**SUBJECT: BRES2412-0011
BUILDING RESIDENTIAL**

Here are the results of all Inspections located at **31 RAY CON CIR:**

Inspection Type: ROUGH IN
Scheduled Date/Time: 1/21/2025
Completed Date/Time: 1/21/2025
Inspector: Steven Gazlay
Result: DISAPPROVED

## 01 Foundation Plan

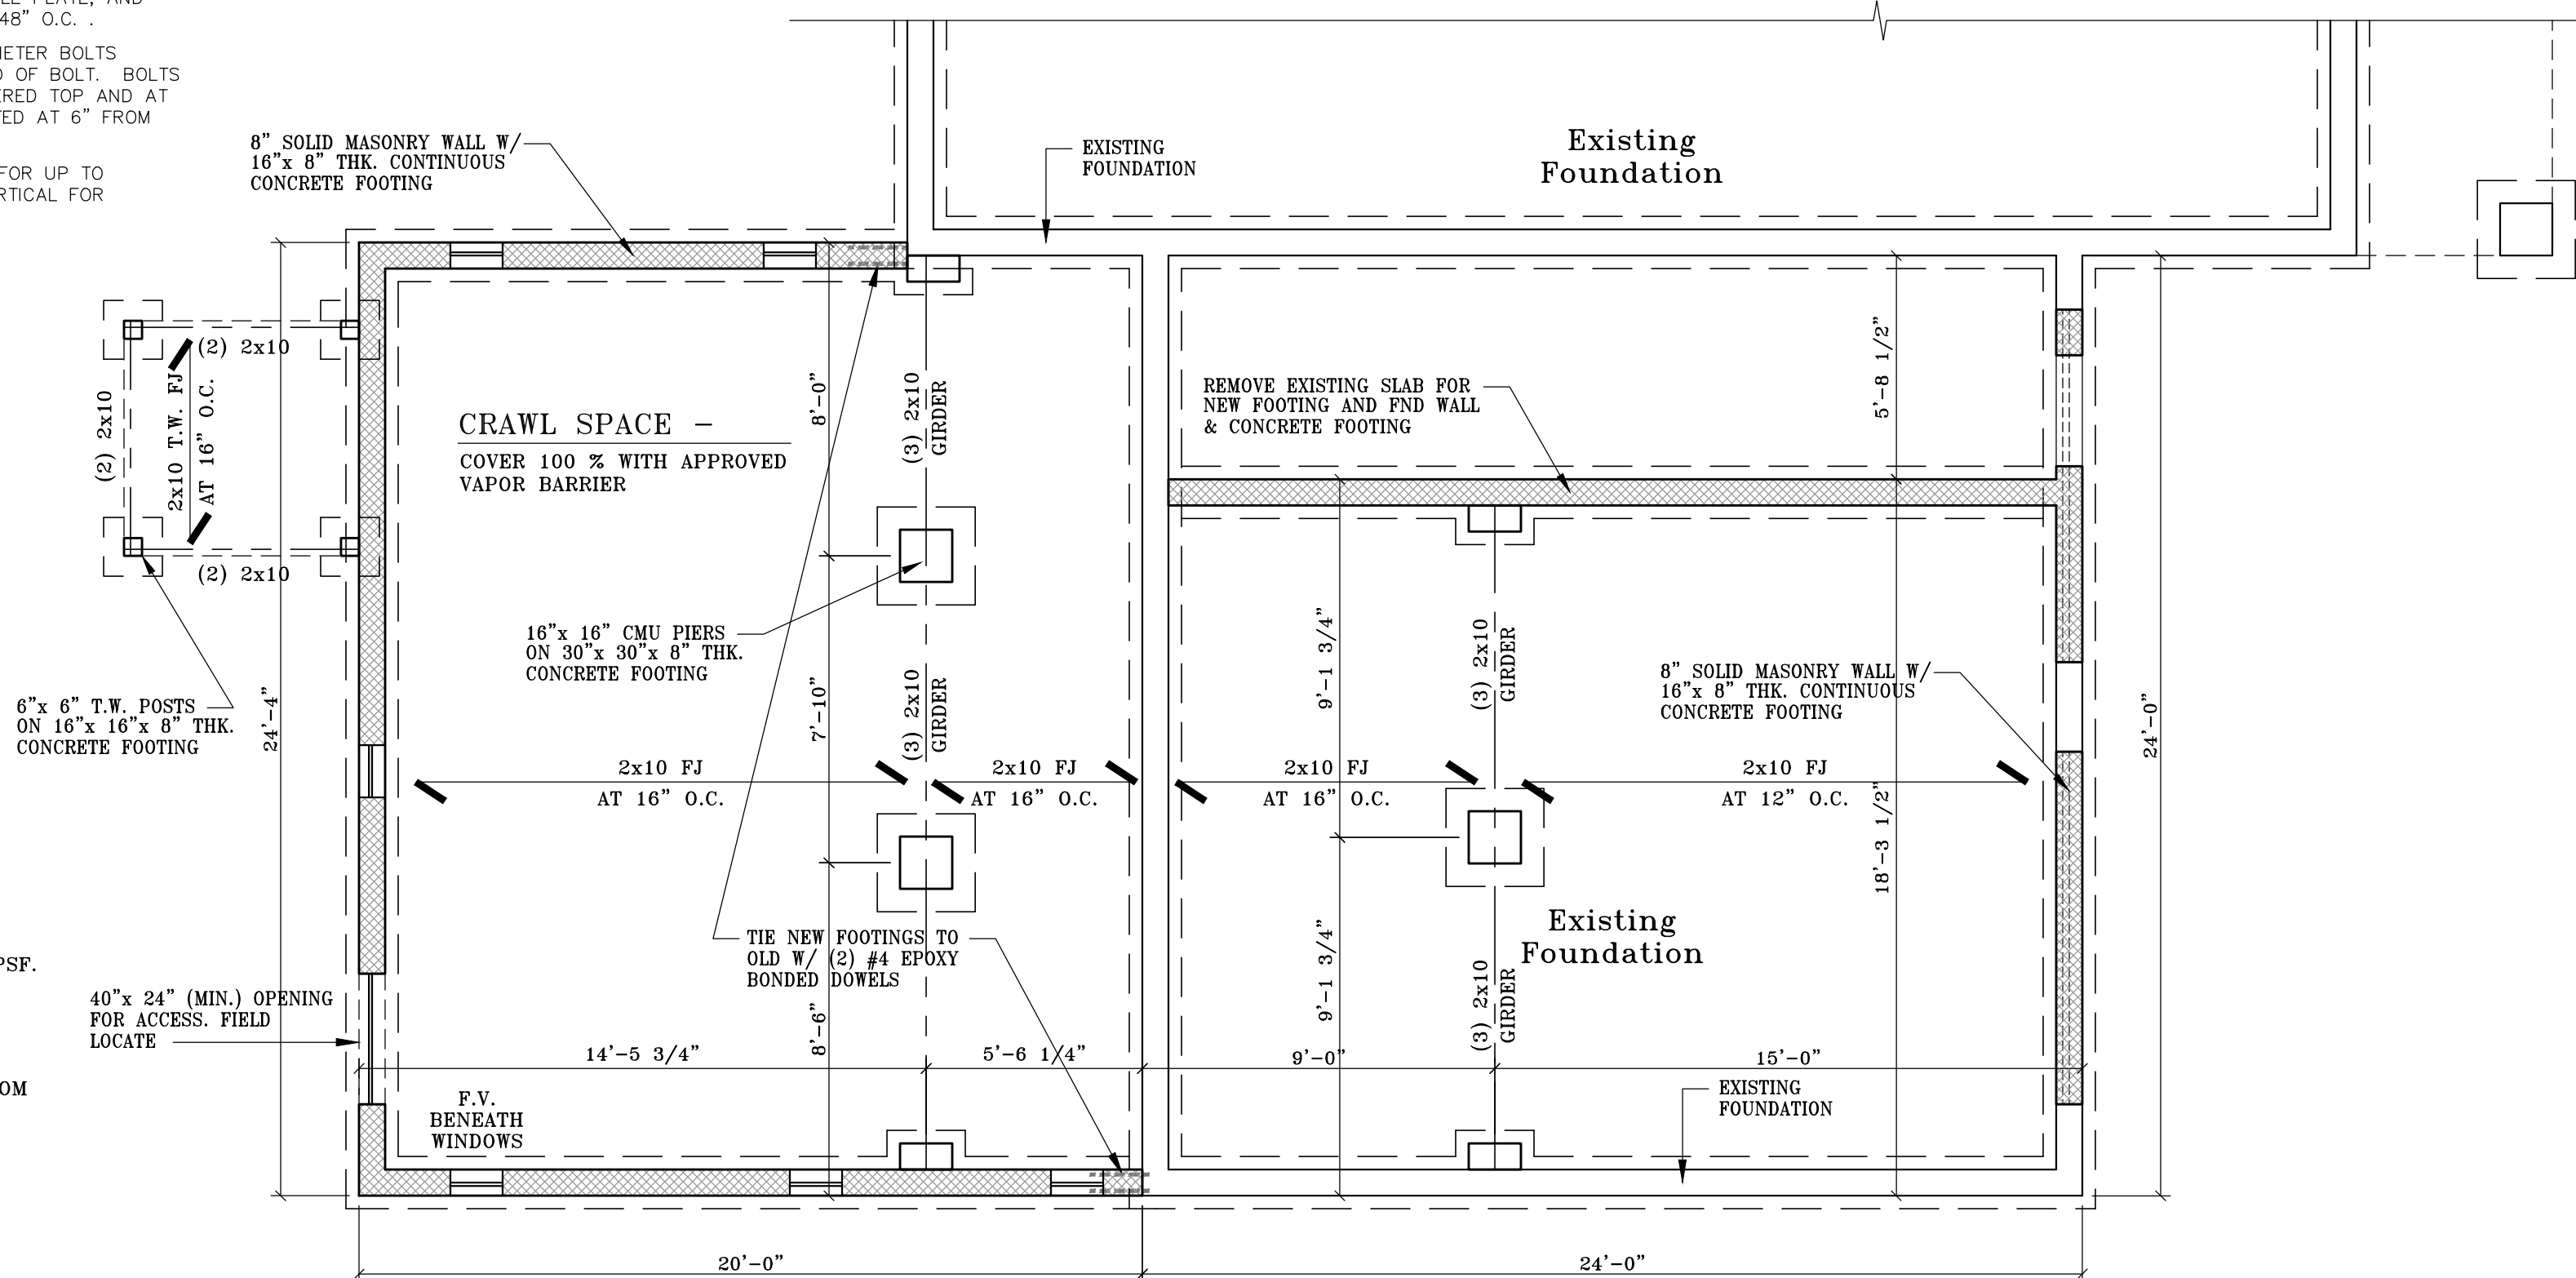
Nail ledger strips on deck. Need to throw bolt drop header. Will need to bolt girder to house. Edge support four gang boxes. Chase not framed out for fireplace insert. Missing nail plates on all plumbing. Seal inch and a half vent at top plate. No plumbing tests. Need to reroute condensate drain and electrical that are existing. Missing partition wall between closet and bath. Nail plate dryer duct. Missing air barrier at tub. Mid story strap plumbing vent. Provide engineering on switch to vault. Cannot tape over bottom of window flange.
